## PLAN REVIEW SHEET

Date: July 27, 2023

Petition #: 2023-041

The site is located adjacent to the Charlotte Transit Center (CTC) and the proposed use is an interim facility for CATS bus operations while the CTC is under redevelopment. CATS is working closely with CDOT and Planning with site plan review and comments. Related items include but are not limited to:

SHEET NUMBER  
**RZ-01**

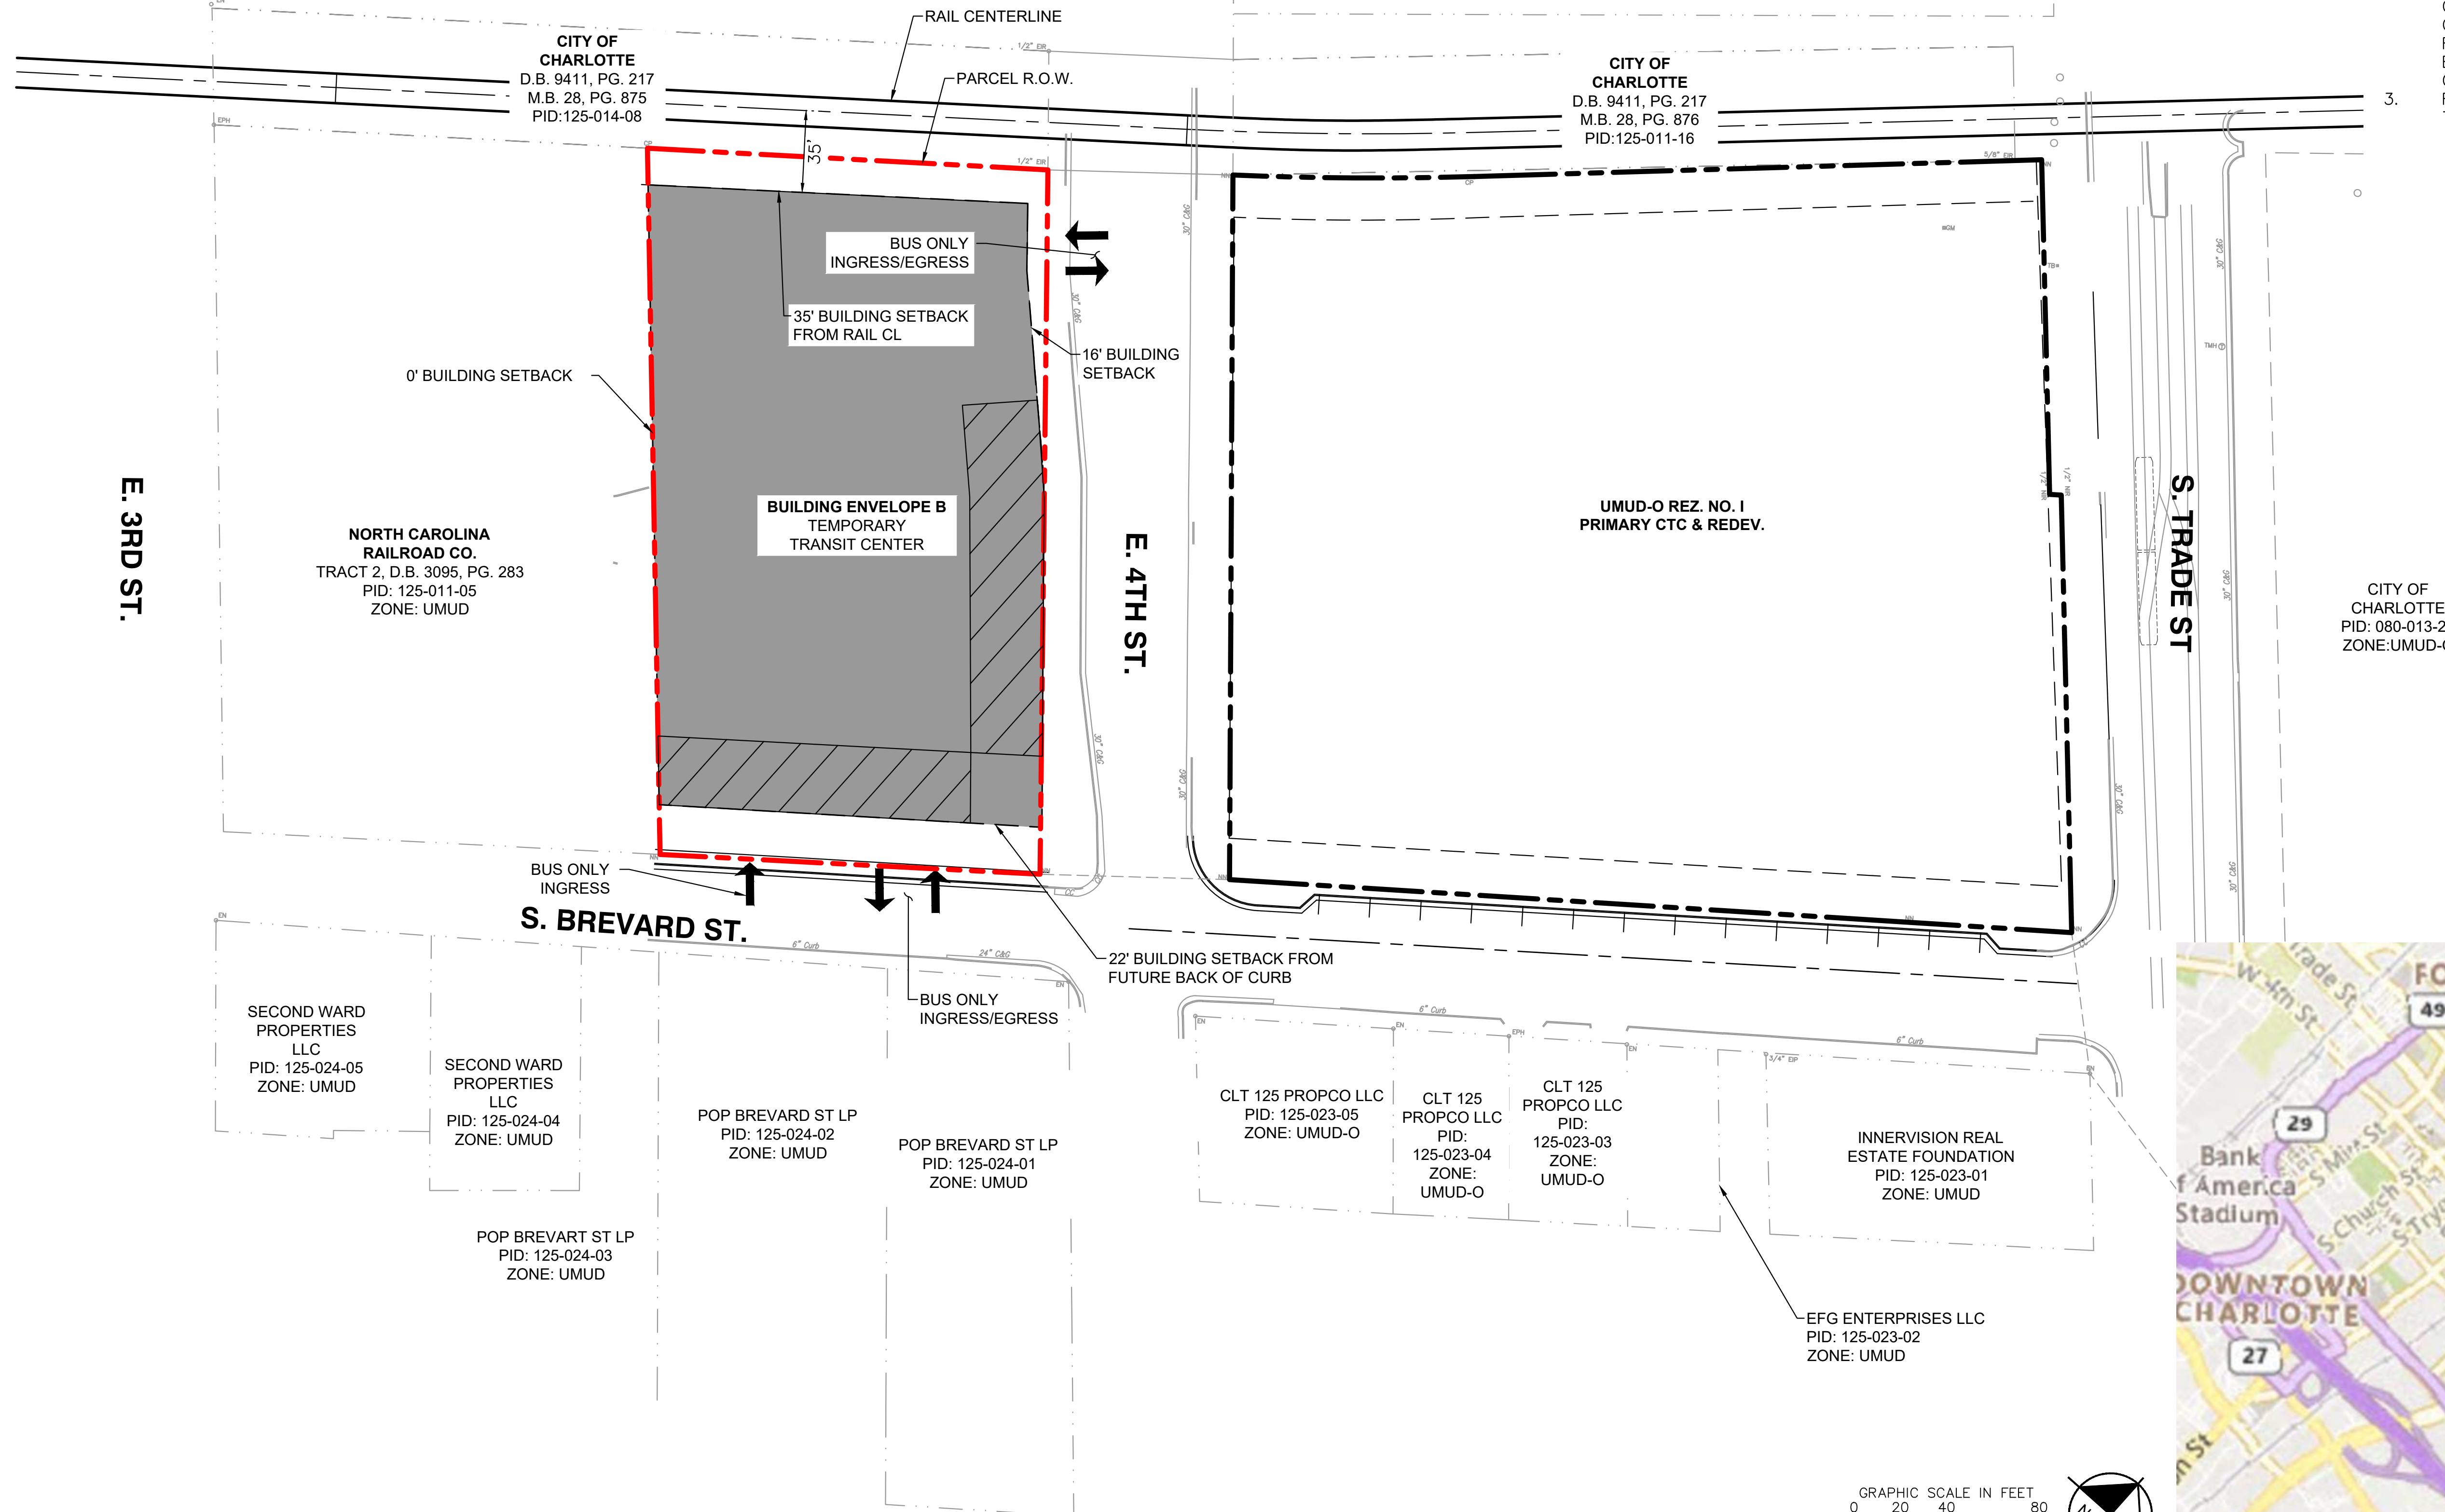
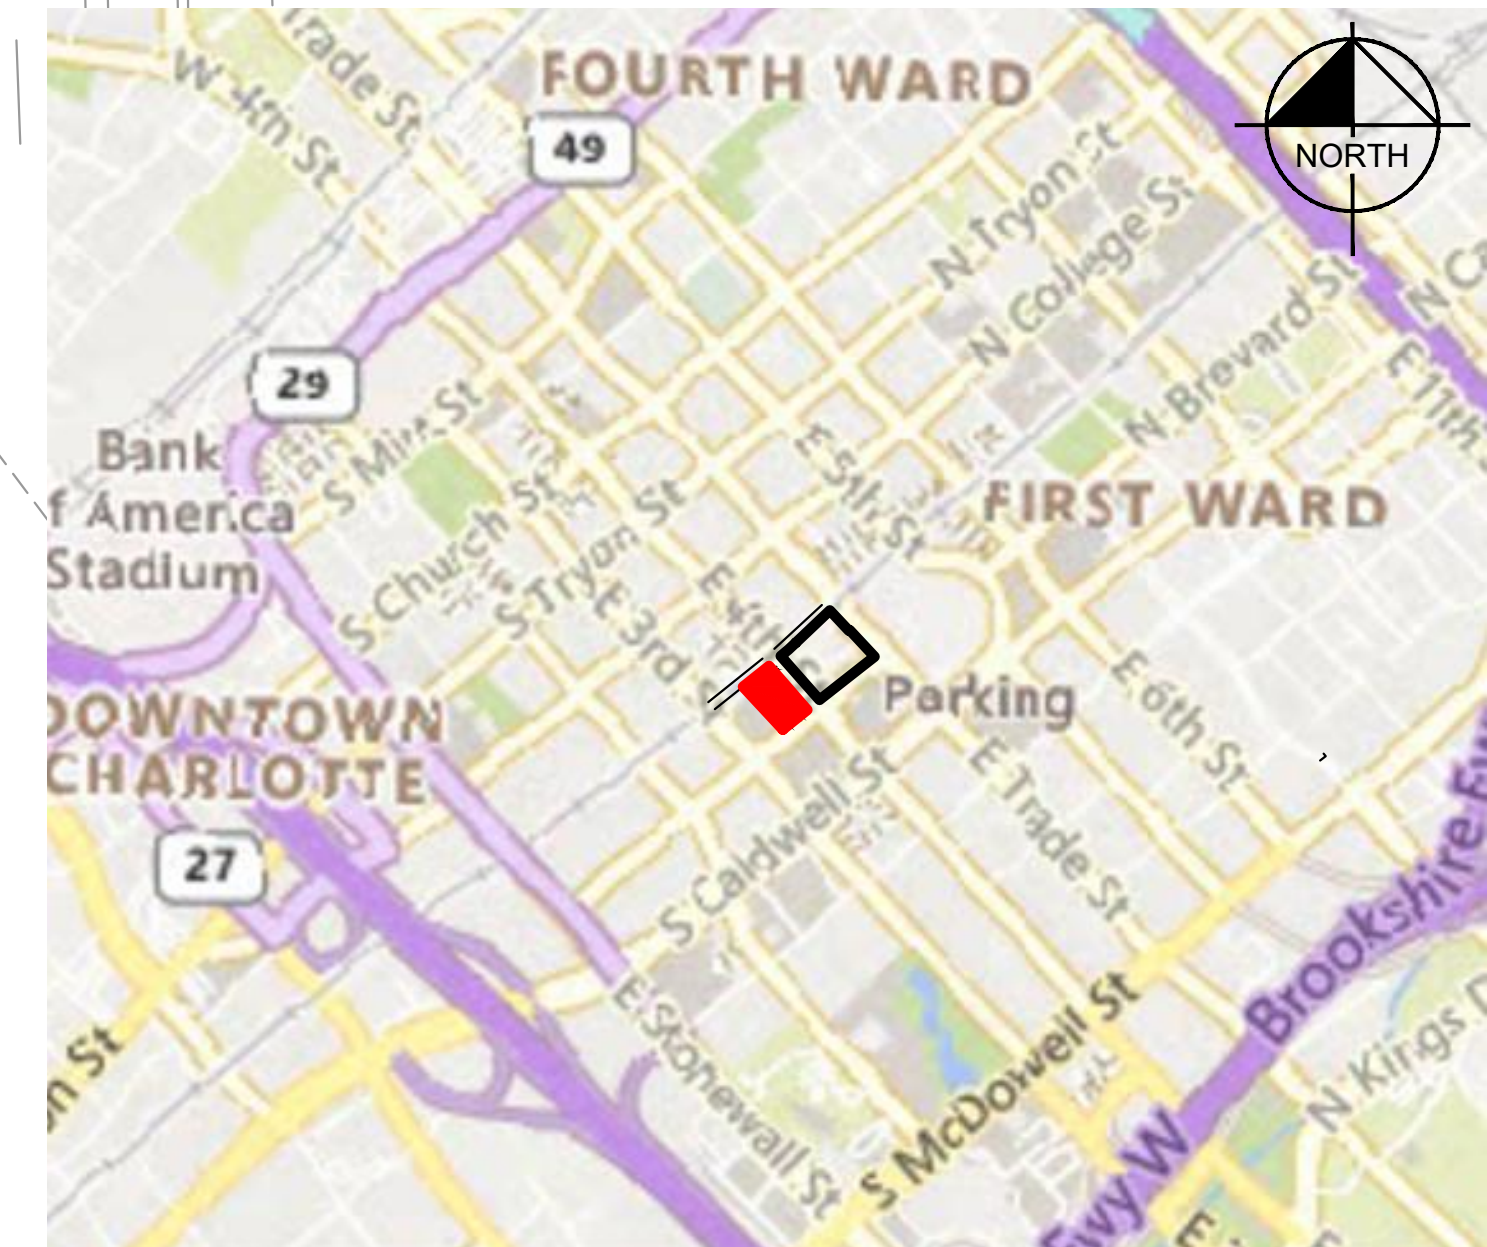
1. Revise site plan and conditional notes to provide a 12ft rail trail along the Blue Line and provide a connection to the Rail Trail to the site.
2. All transportation improvements will be approved and constructed before the site's first building certificate of occupancy is issued. The petitioner may phase transportation improvements if said improvements and phasing are explicitly described in site plan notes.
3. CDOT has the authority to regulate/approve all private street/driveway and public street connections to the right-of-way of a street under the regulatory jurisdiction of the City of Charlotte, per the City of Charlotte's Driveway Regulations.
4. Continue to include CATS Project Manager in the review of permit approvals and other transportation improvements in conjunction CDOT.
